Application No: EP/7/21/HH
Site Address: Little Dormers 23 Upper Drive East Preston BN16 1QN
Description of works: New bay/porch skirt roof to front elevation & single storey front extension to provide additional garaging.

OWQC33587

Drawing Name
Floor Plans and Roof Plan - Proposed

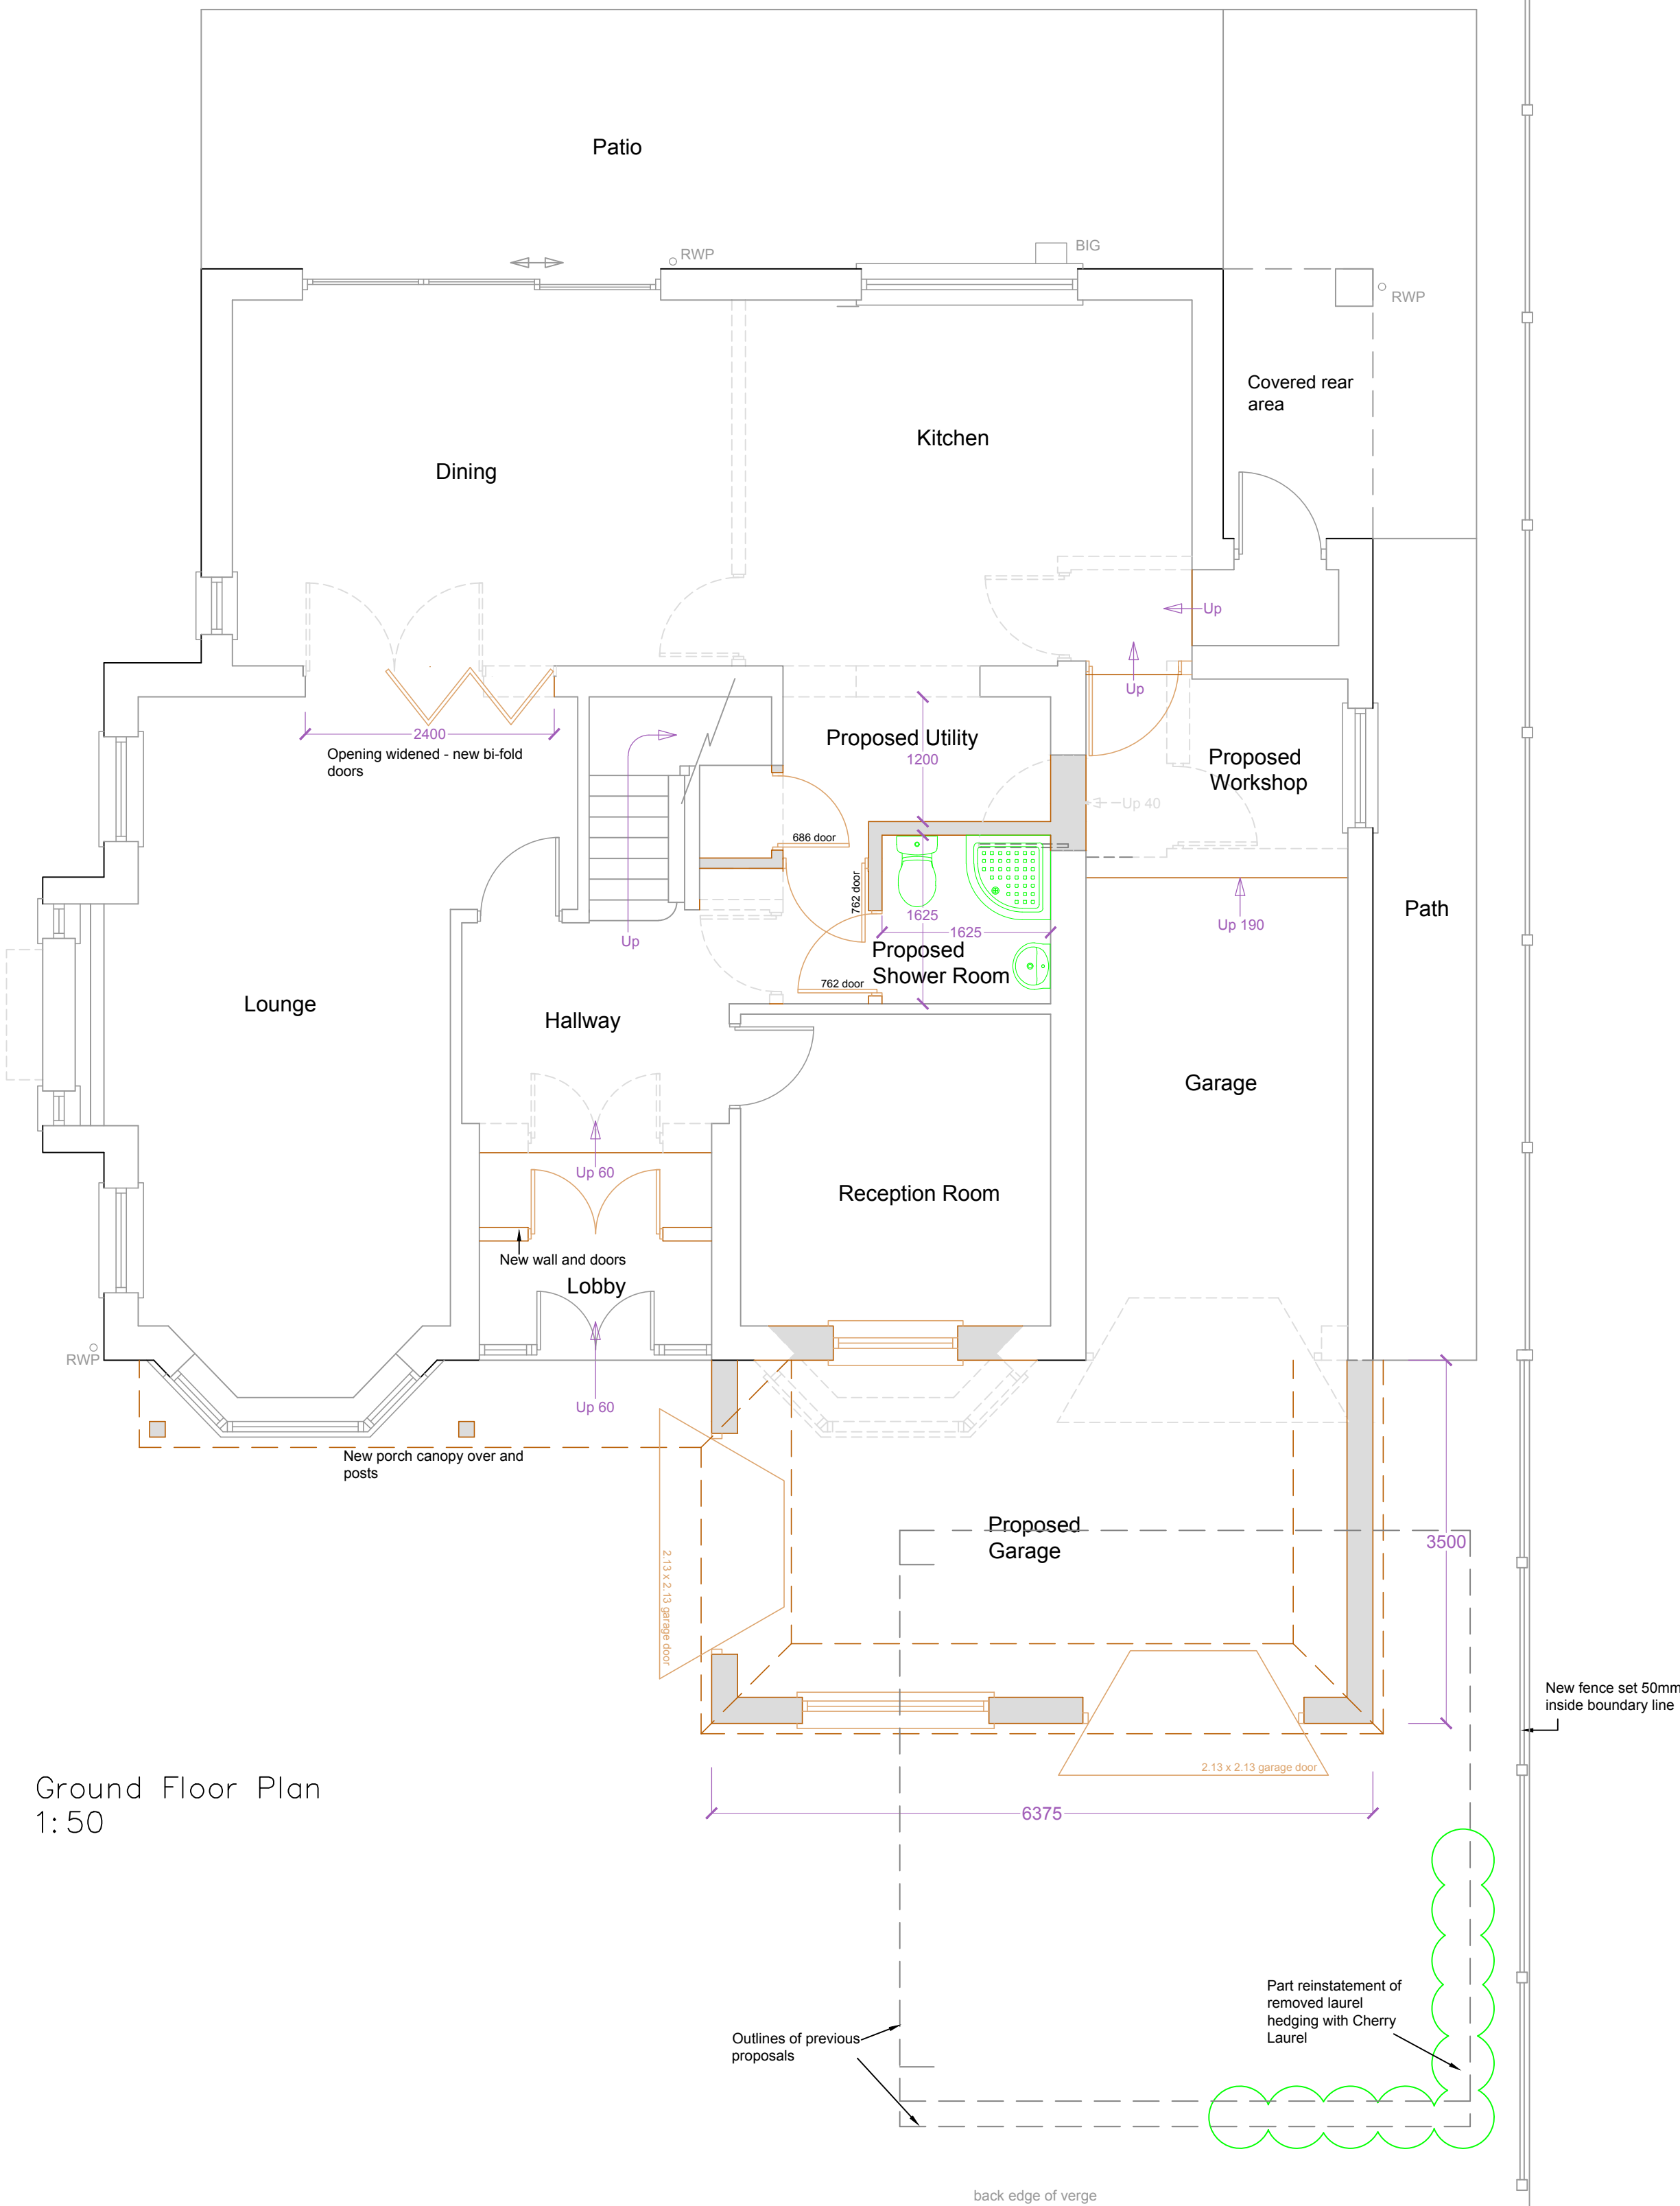
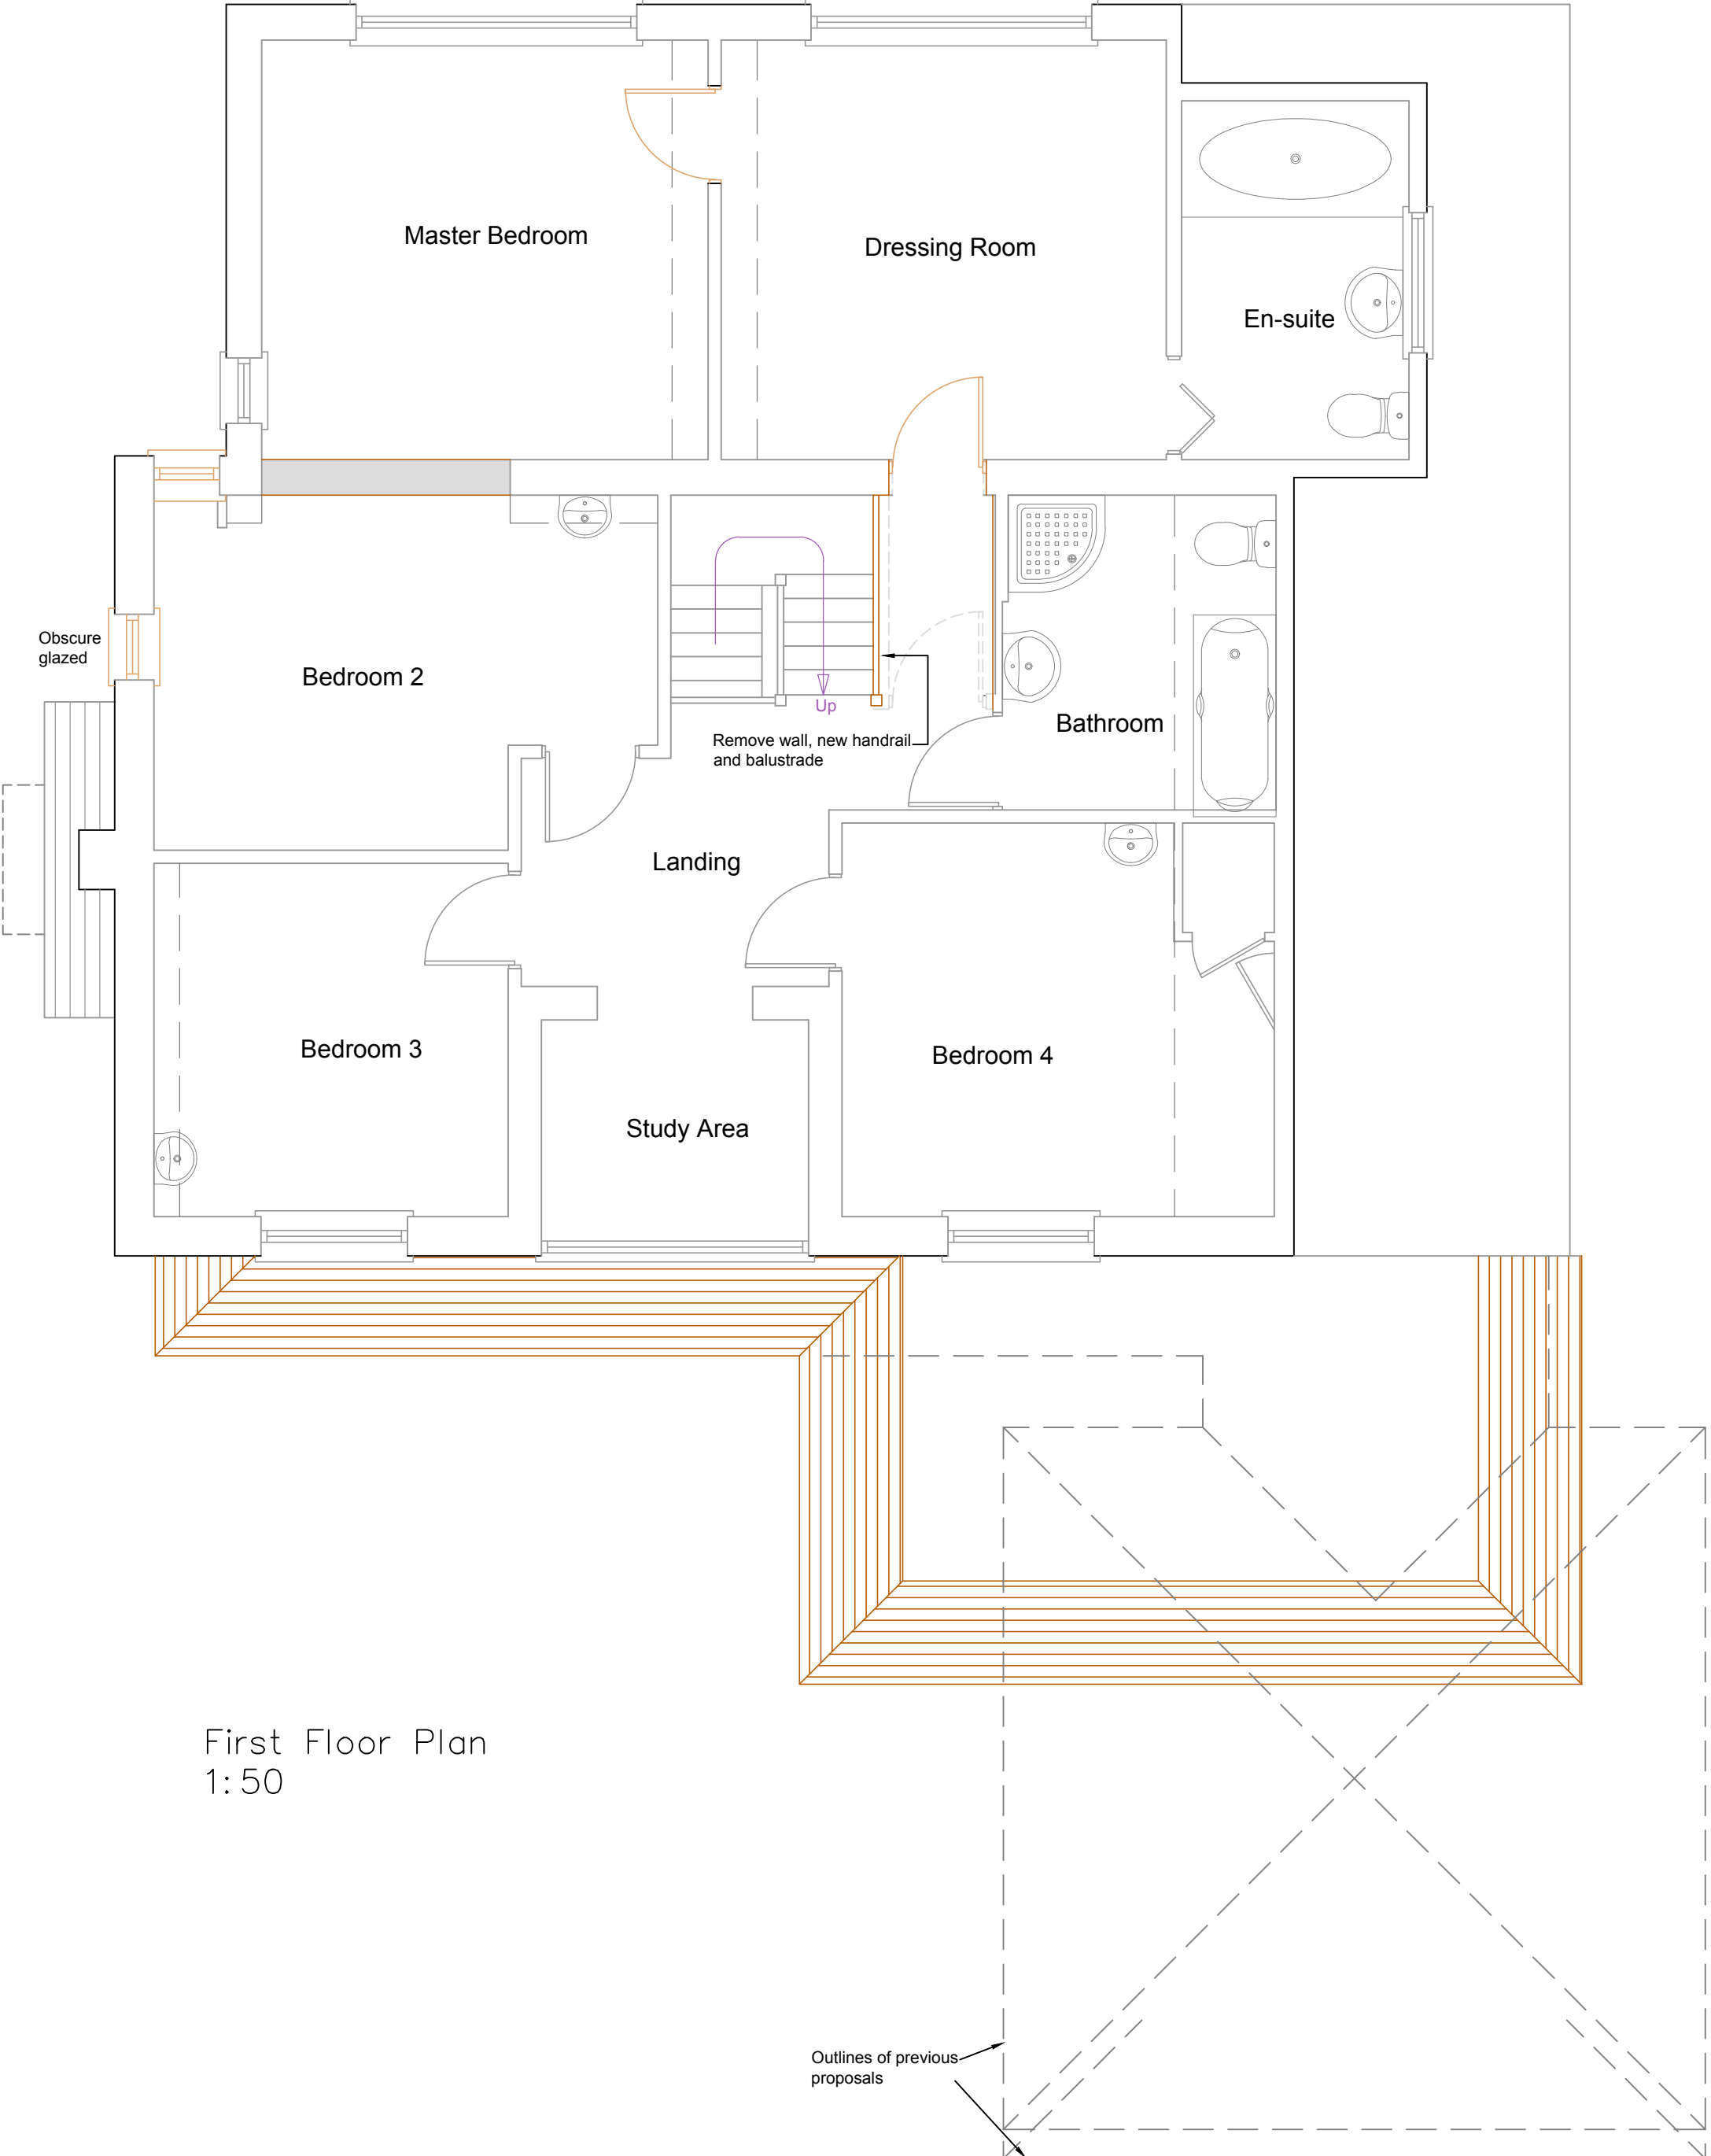
The committee agreed it would not raise any objections to this Application. There was some concern expressed about the fire risk of having a small window in the proposed garage, but it was accepted this would be covered by Building Regulations.
